From: [Tom Leonard](#)
To: [Deb Estrada](#)
Cc: "[Marianne Leslie \(mleslie.llddev@gmail.com\)](mailto:Marianne.Leslie@mleslie.llddev@gmail.com)"
Subject: Comments of Concern RE: SUB19-002 EAST SEATTLE SCHOOL SUBDIVISION
Date: Sunday, January 21, 2024 4:11:12 PM

Comments of Concern for SUB19-002 East Seattle School Parcel Subdivision

PRELIMINARY GRADING PLAN
2825 W MERCER WAY
PRELIMINARY PLAN
 PARCEL #2174502425
 CITY OF MERCER ISLAND WASHINGTON

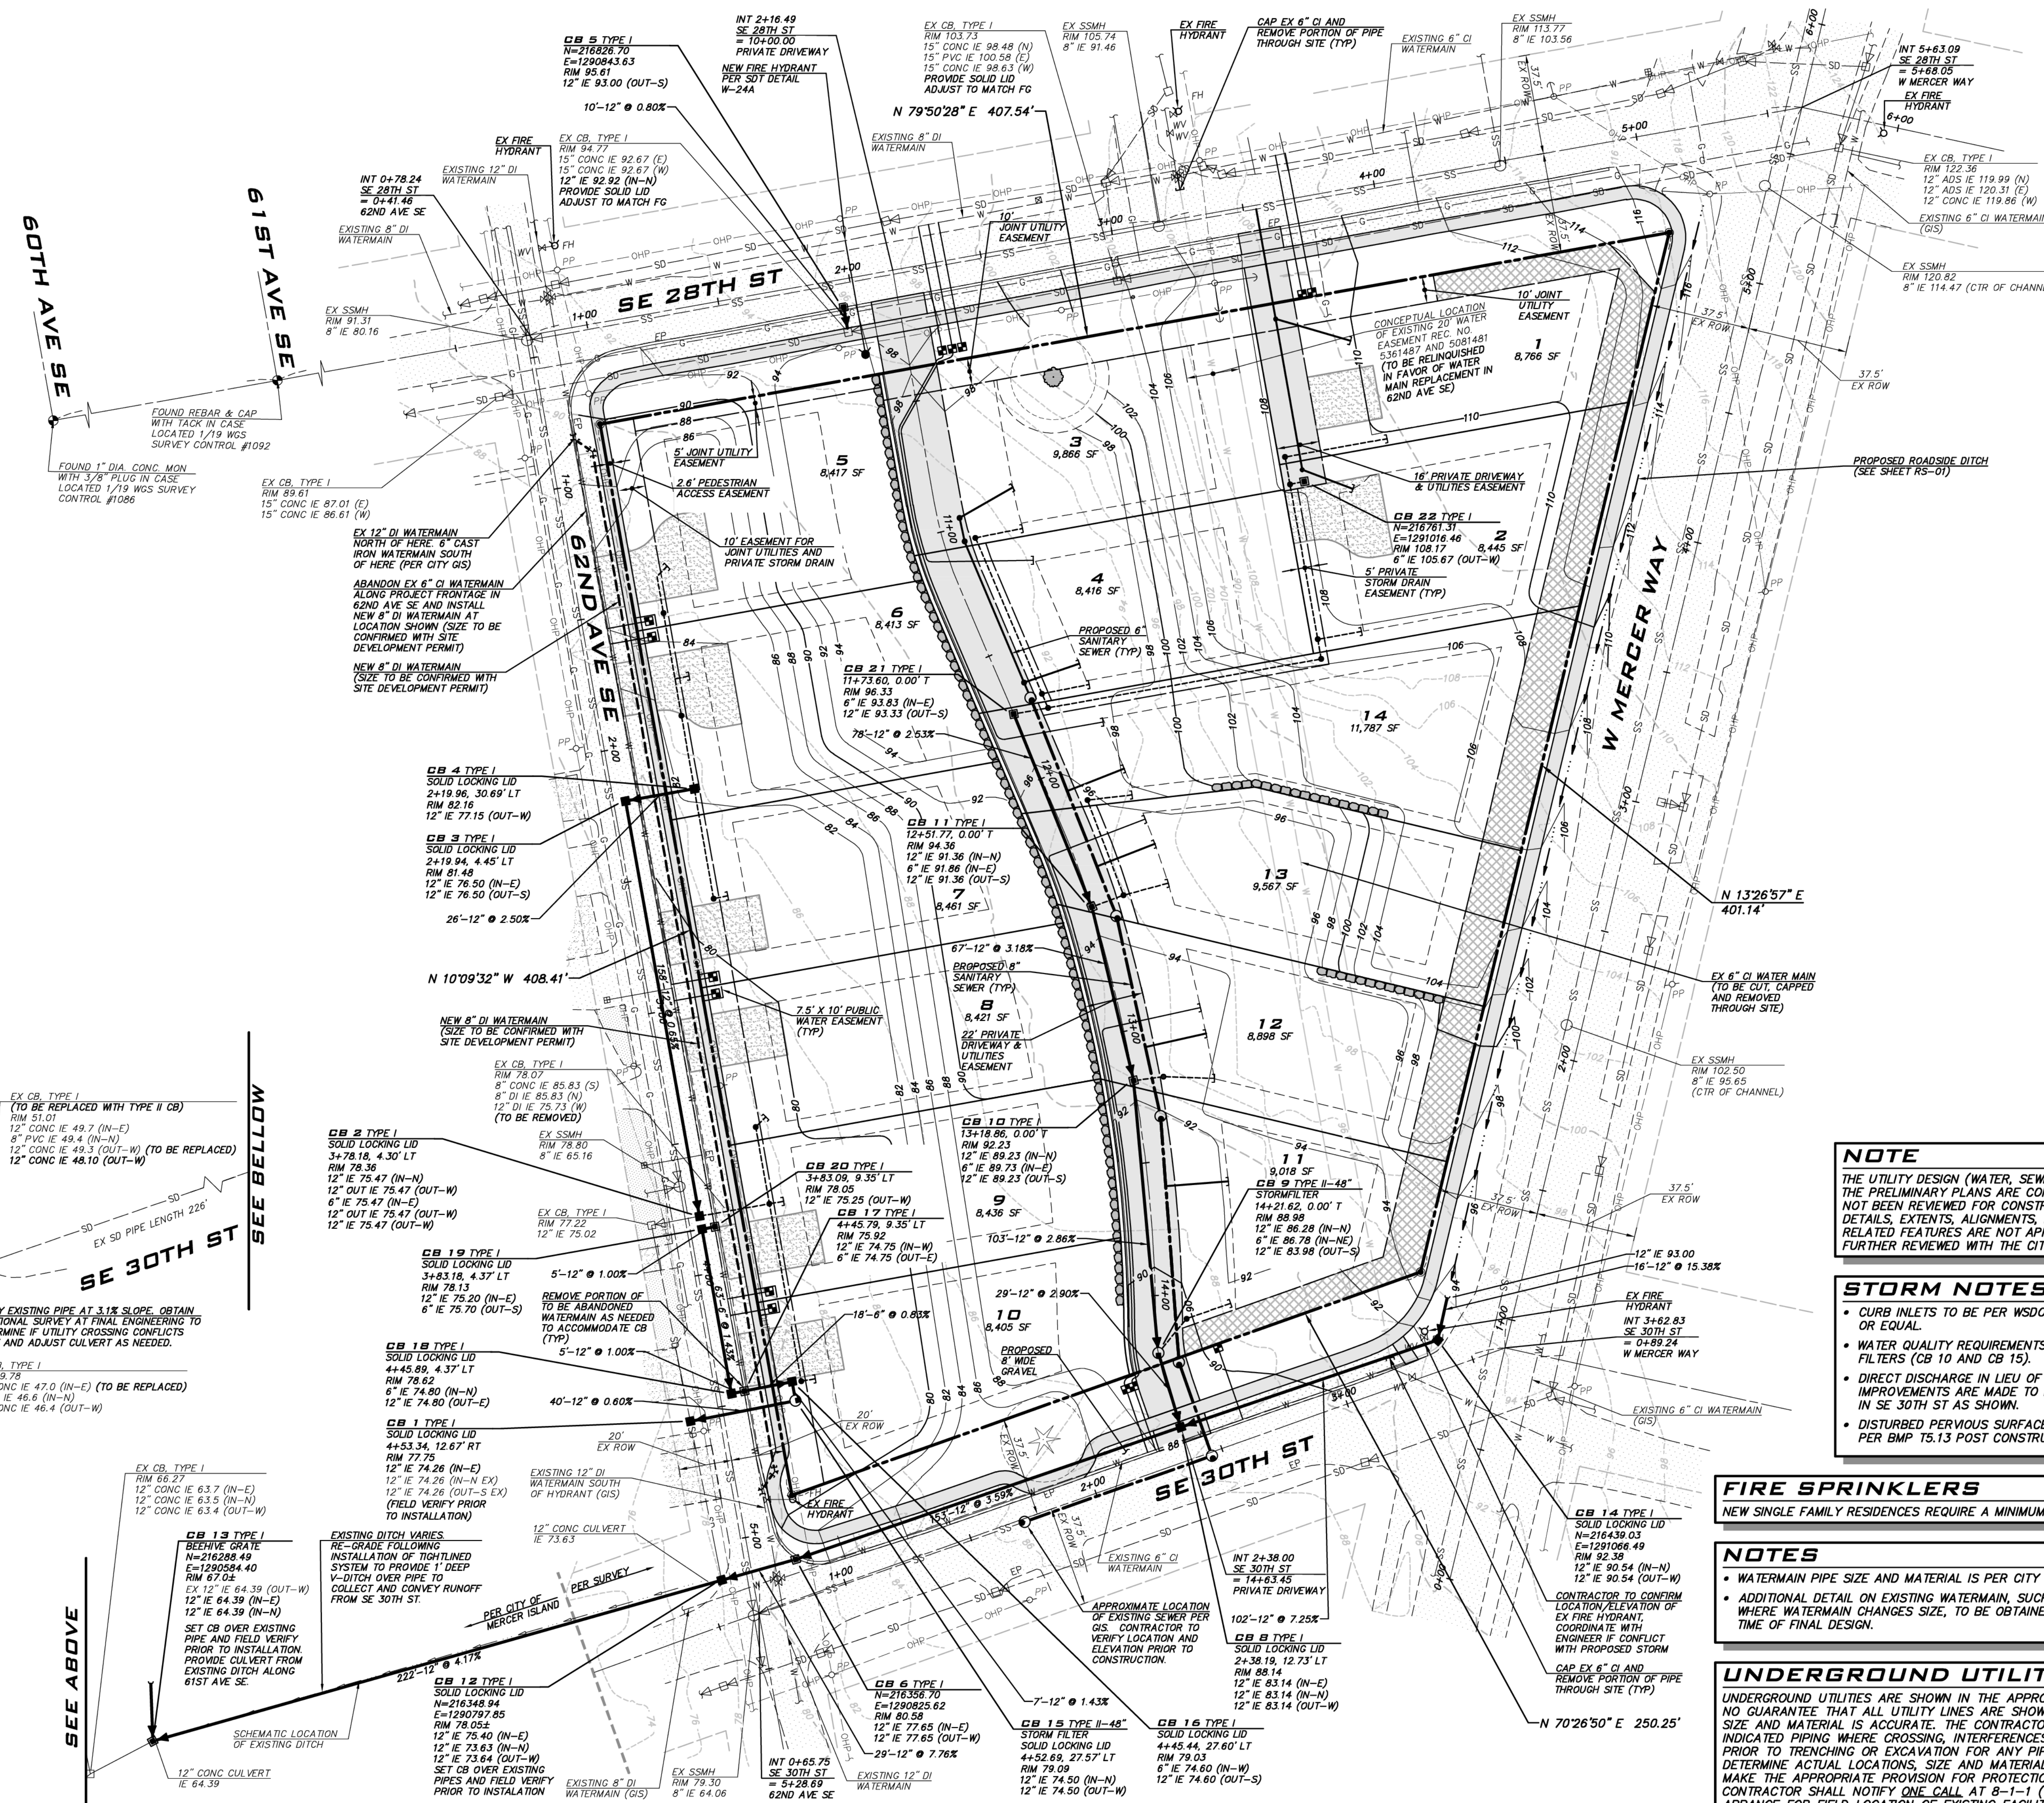
2. **Height of structures.** The code is for 30 foot height. This should enforced AND no variances should be approved. Also, the code is from the existing or altered grade height, **which ever is lower.** With the grading plan, the 30 foot building height should be from the building pad elevation for those lots with lowered pads and existing of those with elevated building pads.

PRELIMINARY UTILITY PLAN
2825 W MERCER WAY
 PRELIMINARY PLAT
 PARCEL #2174502425
 CITY OF MERCER ISLAND WASHINGTON

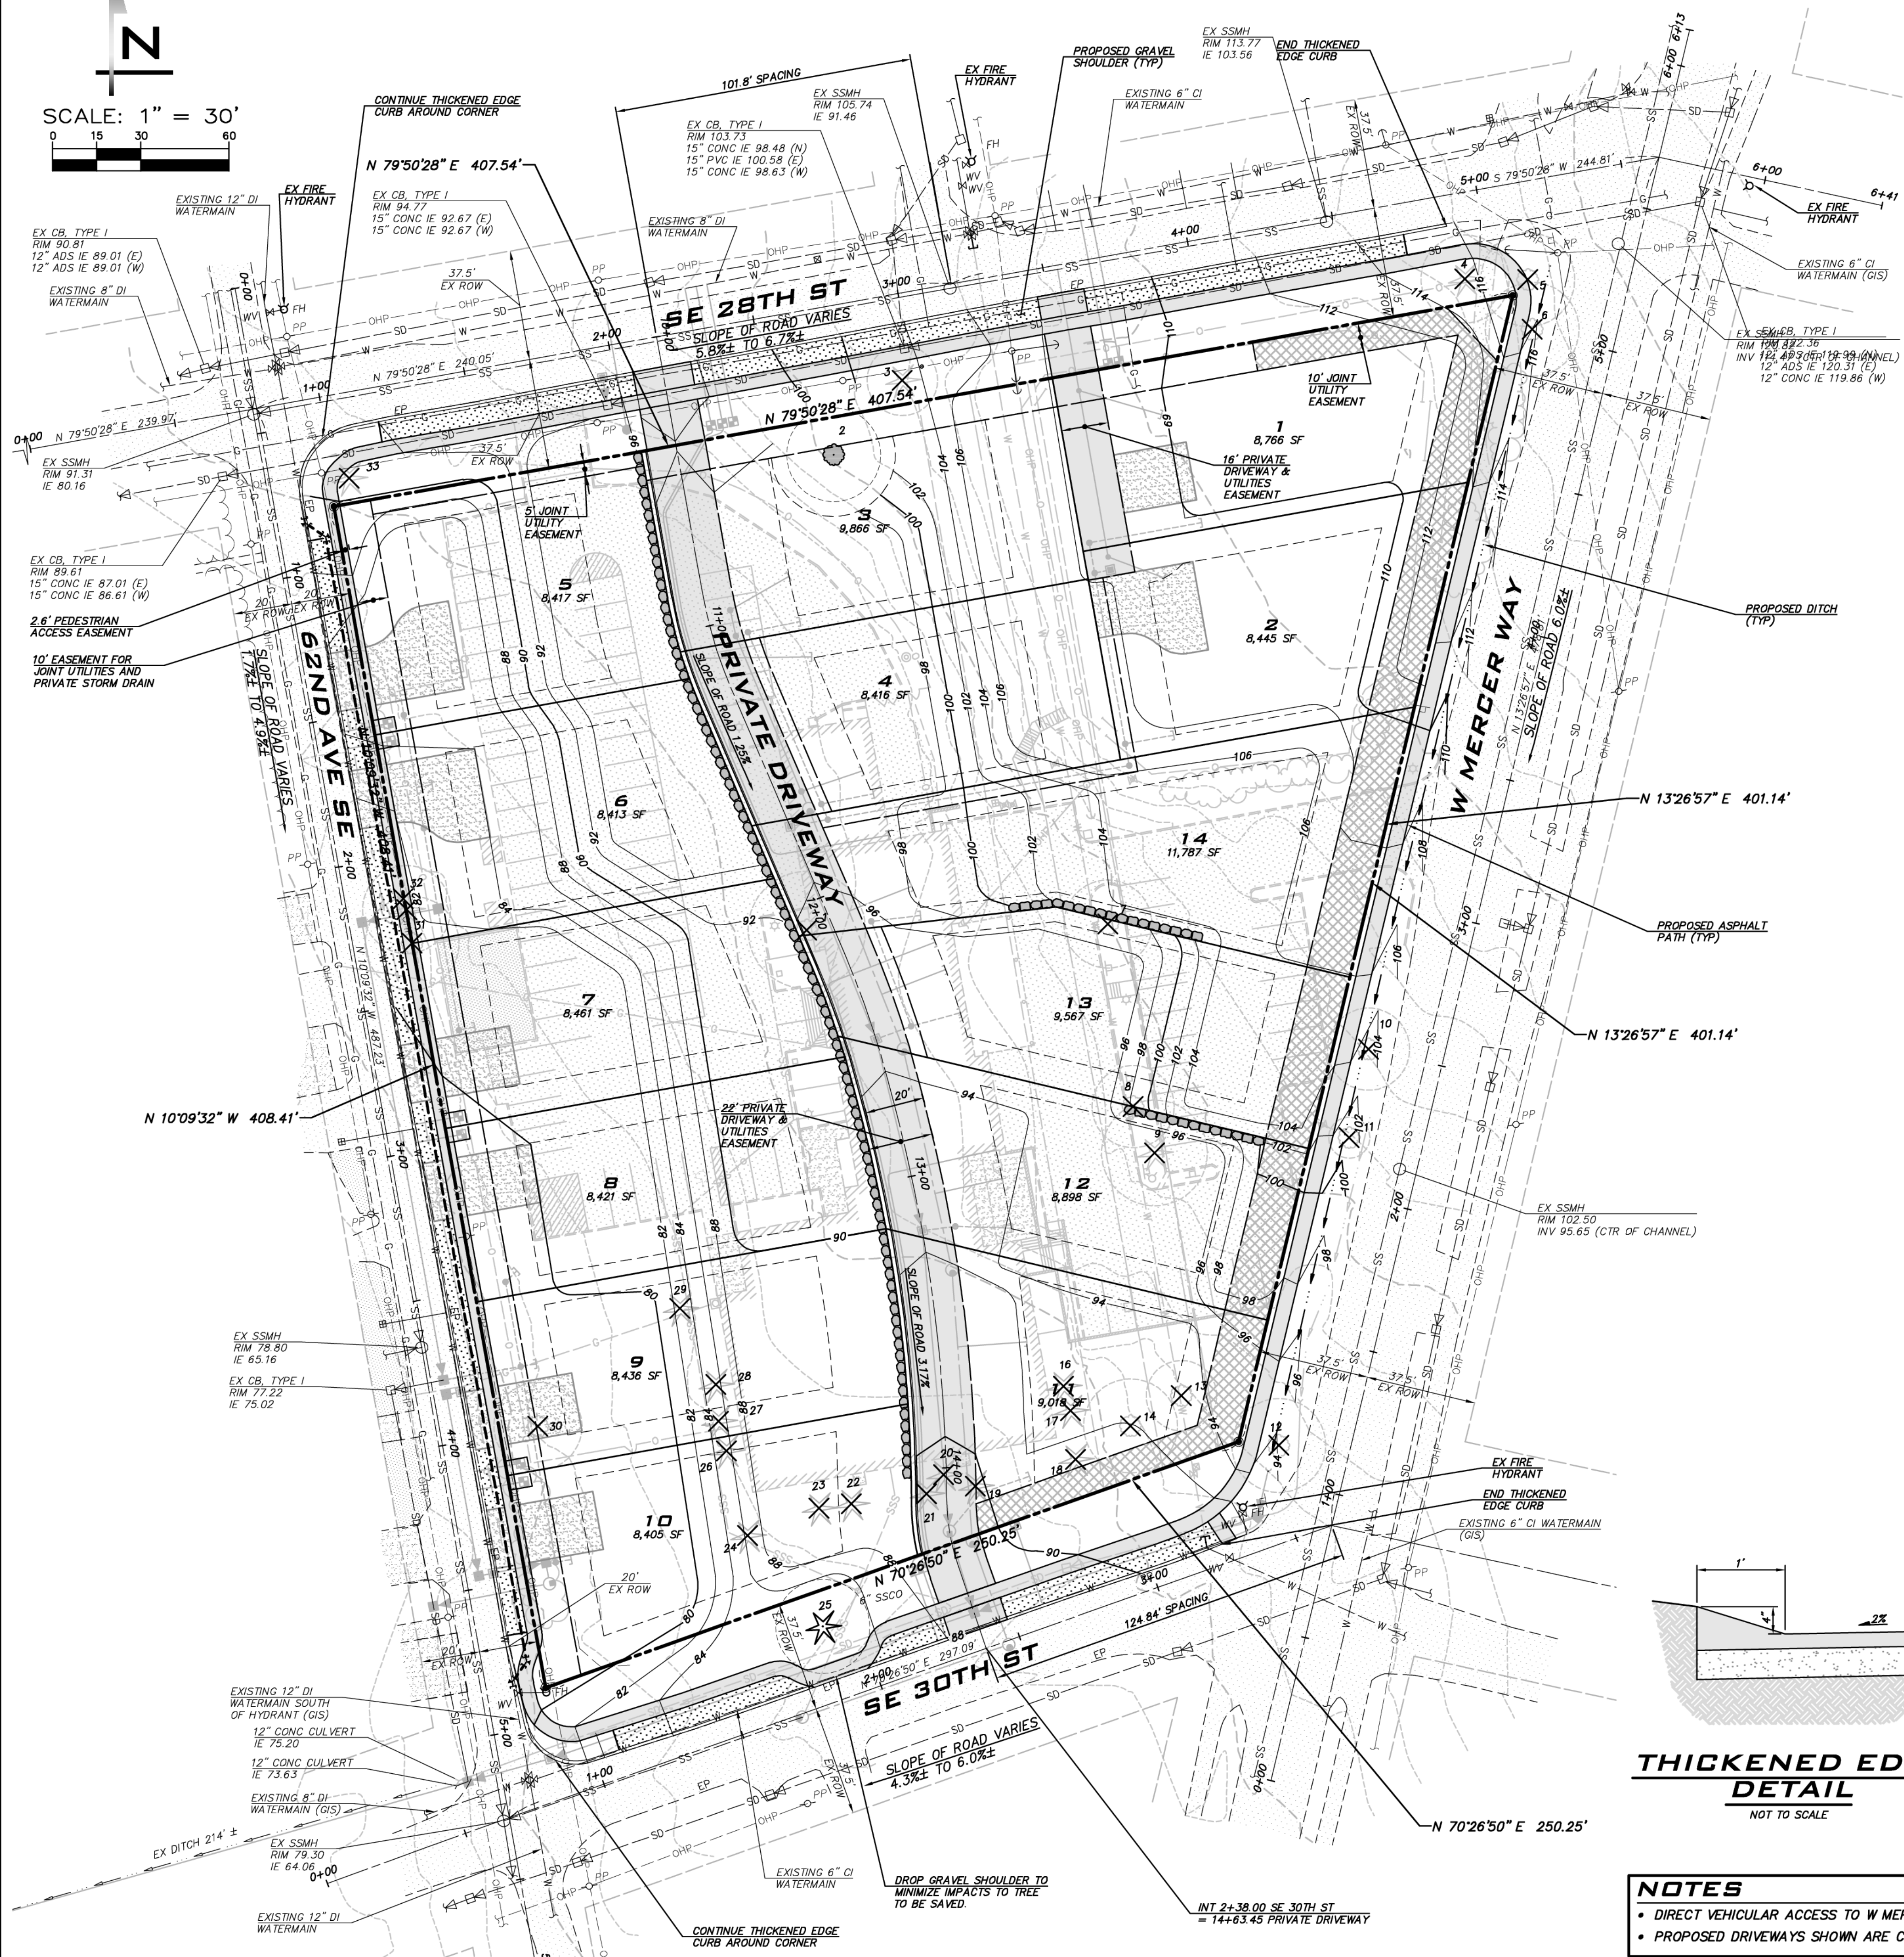
6. There should be **structured Storm Drainage and sedimentation facilities** to capture and pre-treat the runoff of this dense community with significant pavement and Lot coverage impacts.

- a. Note: We have done land development in King County recently... AND even in rural King County, for an 80 acre 8 lot development, we were required to build a significant sedimentation ponds with directional drainage to it. **That such requirements are not included here while we are so proximate to Lake Washington, is inconceivable.**
